# DEVELOPMENT HEARING OFFICER

**PR-2021-009917**

SD-2024-00092

REPLAT OF 2 EXISTING LOTS

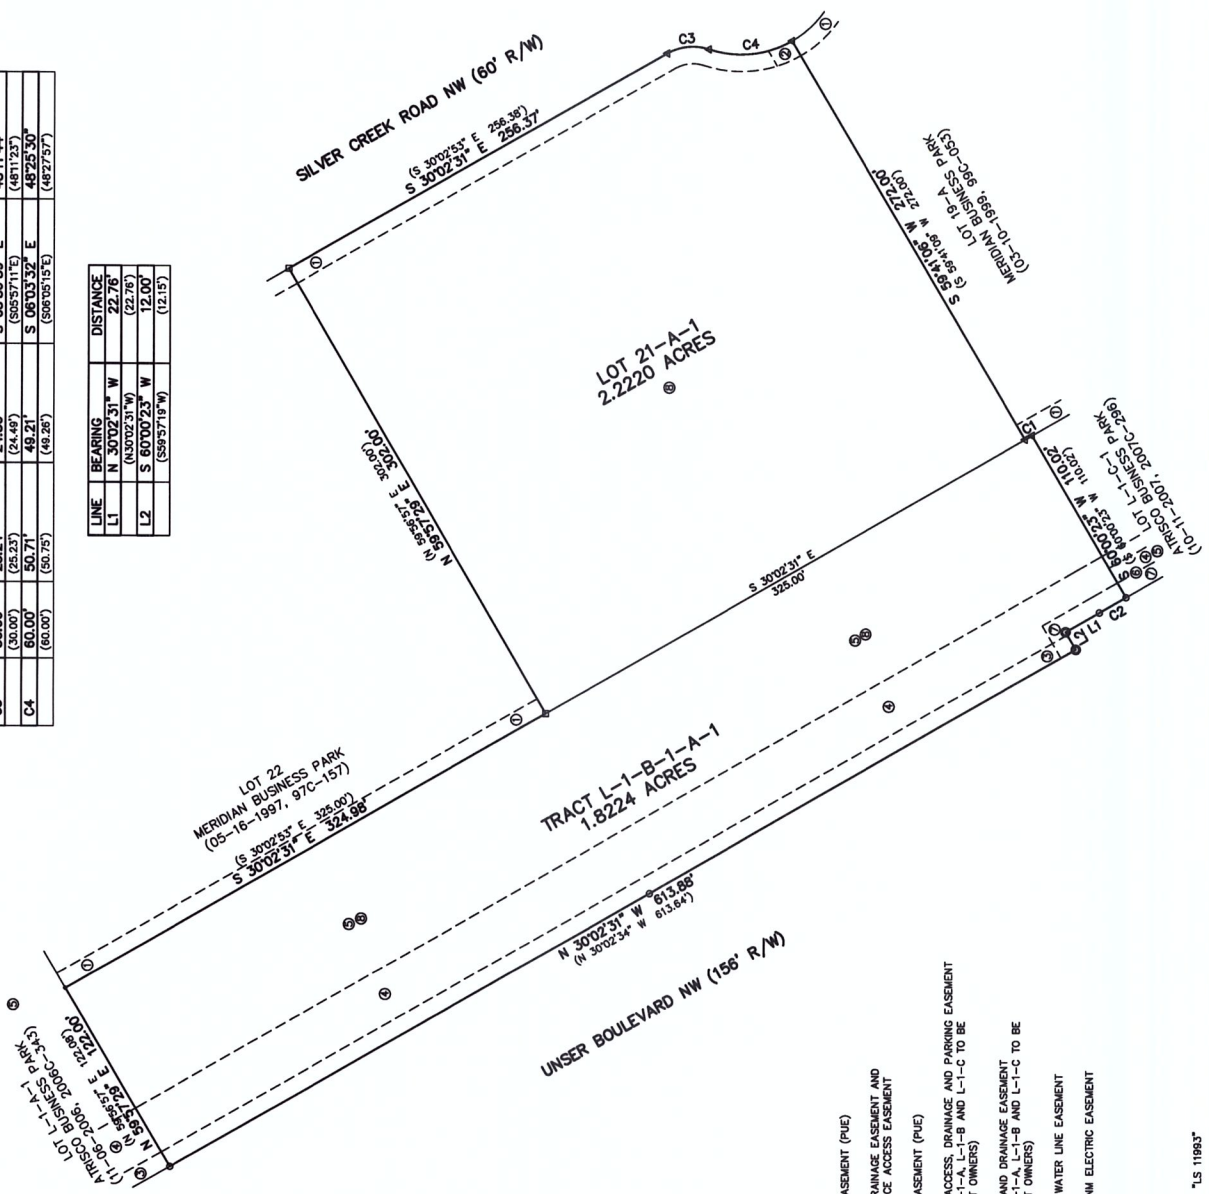
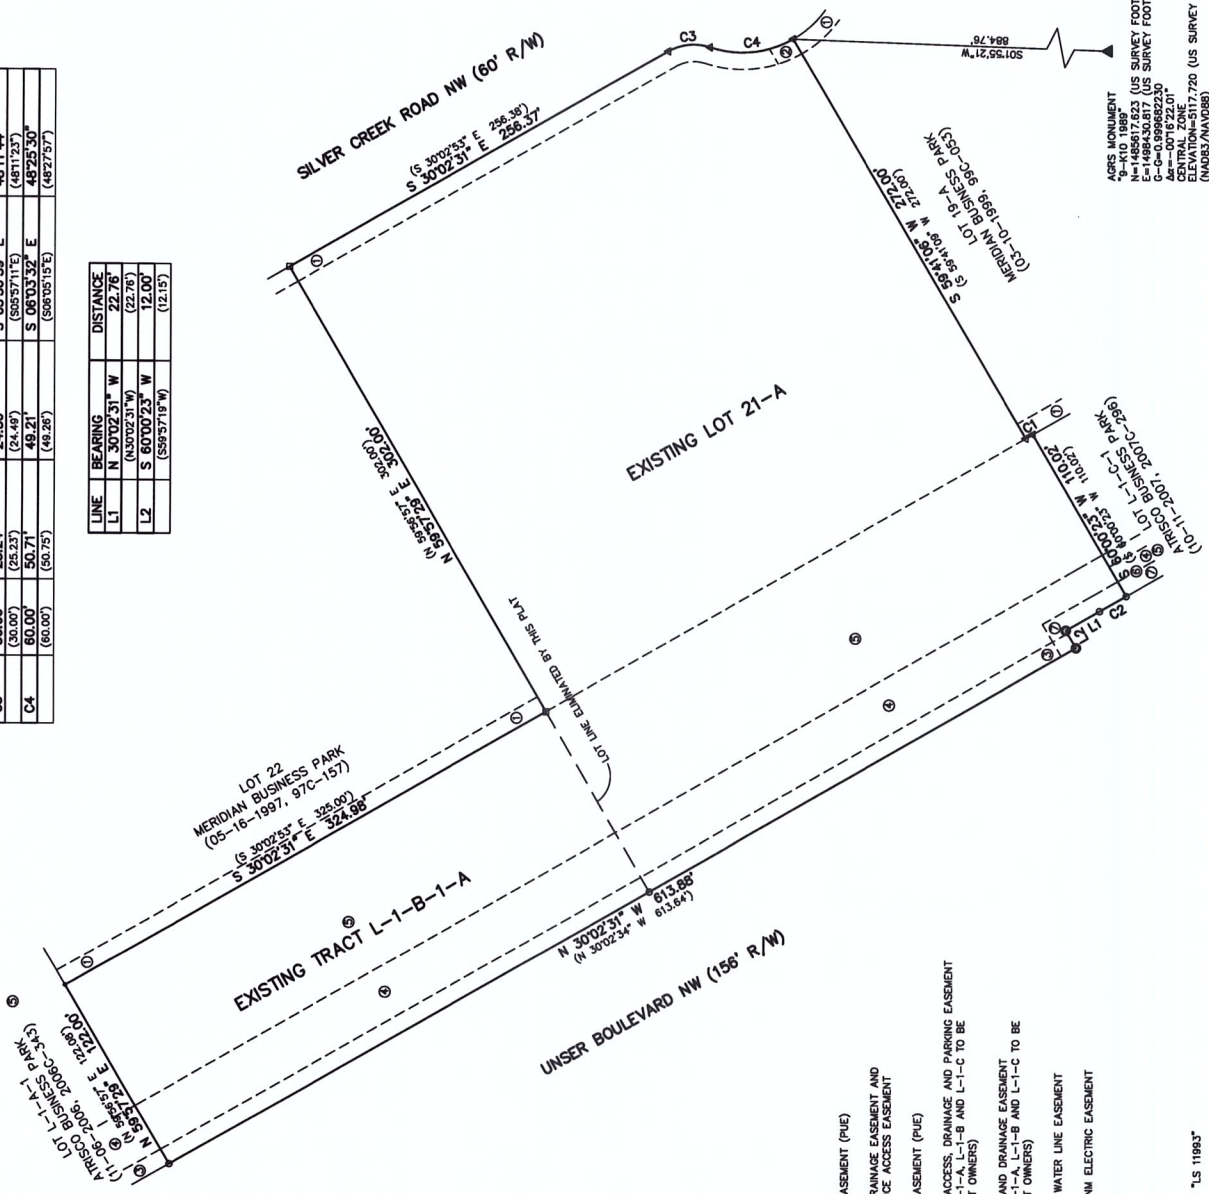
- The Sketch Plat for the proposed replat included a conceptual Site Plan featuring two commercial buildings and improvements largely on Tract L-1-B-1-A-1. However, portions of the proposed parking on the conceptual Site Plan were depicted on Lot 21-A-1; please confirm if future development is proposed on Lot 21-A-1.

- Project and application numbers must be added to the Plat sheet.
- Confirm the approval of the existing driveway and curb-cut off of Unser Boulevard.
- DXF File must be approved by AGIS office before final sign-off of this Preliminary/Final Plat request.

- Please note that per the Atrisco Business Park Master Development Plan, properties adjacent to Unser Boulevard shall have a 6-foot wide sidewalk with a minimum 12-feet between the back of curb and the sidewalk. An analysis of the site in Google Street View (see picture below) appears to depict a sidewalk at least 6-feet in width, but the landscape buffer doesn't appear to be a minimum of 12-feet in width between the back of curb and the sidewalk as required by the Atrisco Business Park Master Development Plan.

1. Unser is a Principal Arterial and requires 6' sidewalk with a 5' – 6' landscape buffer. Silver Creek and Meridian are local roads and require 5' sidewalk with 4' – 6' landscape buffer. Please provide a diagram dimensioning sidewalks and landscape buffers.
2. As a reminder, a TCL will be required prior to site plan or building permit. Also, a Traffic Scoping form will need to be submitted to Curtis Cherne ([ccherne@cabq.gov](mailto:ccherne@cabq.gov)) to determine if a TIS will be required.
